From: Amanda Scholes on behalf of Planning.Responses
Sent: 03 November 2021 08:53
To: Planning Scanning
Subject: FW: Planning Re-Consultation on: A/212/21/DOC

Thank you for re-consulting us, we have the following comments regarding condition 4.

Application No:	A/212/21/DOC
Registered:	4th October 2021
Site Address:	Merry England Dappers Lane Angmering BN16 4EN
Grid Reference:	507260 105051
Category:	Discharge of Conditions
Description of Works:	Approval of details reserved by condition imposed under A/91/18/PL relating to condition 4-surface water drainage.

Formpave permeable block paving private parking area construction

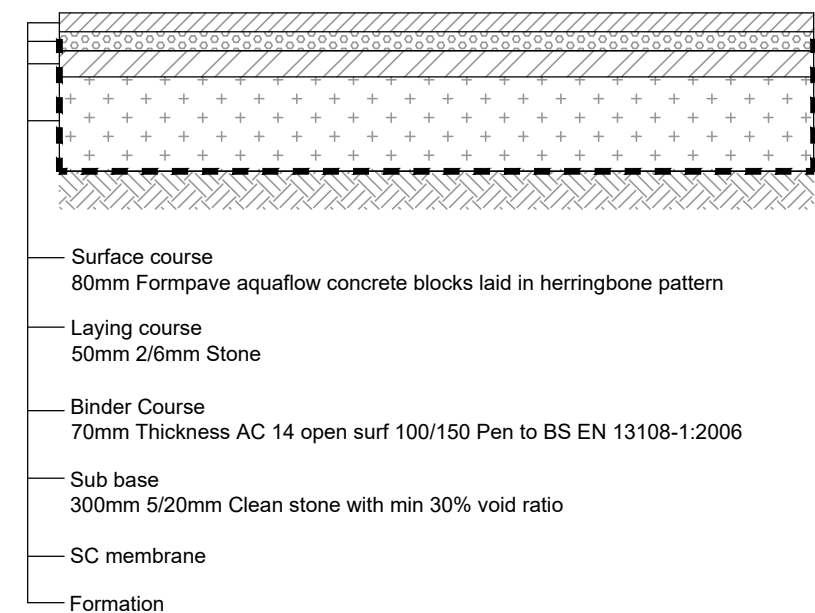
It appears that there are some errors with the levels stated, please can the applicant review to ensure any typos are corrected to ensure that diffusers are located above formation level and a gravity connection from paving areas to the surface water drainage network can be achieved.

Formpave Diffuser tank construction

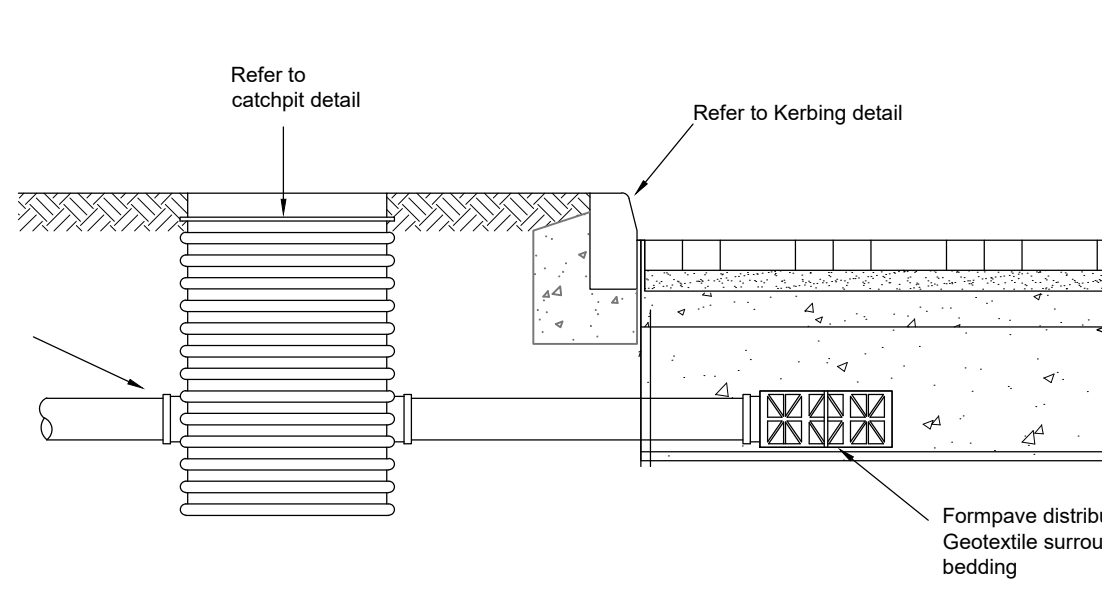
The construction detail drawing implies that diffusers are the inlets to the permeable paving and that fin drains are proposed as outlets. However the arrangement of the diffusers and the levels stated on the layouts imply that the diffusers are actually being used as collectors at the base of permeable paving. My understanding is that the permeable paving is meant to infiltrate with high level overflow to the network, therefore levels should be revised so that the diffusers/ collectors are not set at the very base of the sub-base.
